REQUEST

Current Zoning: R-6MF(CD) (multi-family residential, conditional)
Proposed Zoning: UR-2(CD) (urban residential, conditional)

Approximately 0.30 acres located on the south side of Hoskins Road and west side of Gossett Avenue.

The petition proposes to adaptively reuse the existing building onsite with six multi-family dwelling units at a density of 20 units per acre. The site was originally an accessory building to Hoskins Mill.

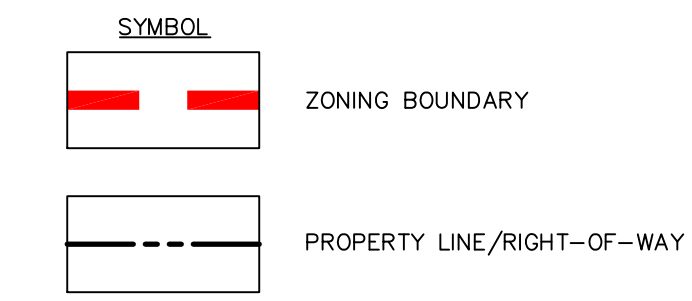
- ~~1. Please provide dimensions for the existing sidewalk along Gossett Ave. The existing sidewalk must be a minimum of 6' to be used for UR zoning.~~ **ADDRESSED**
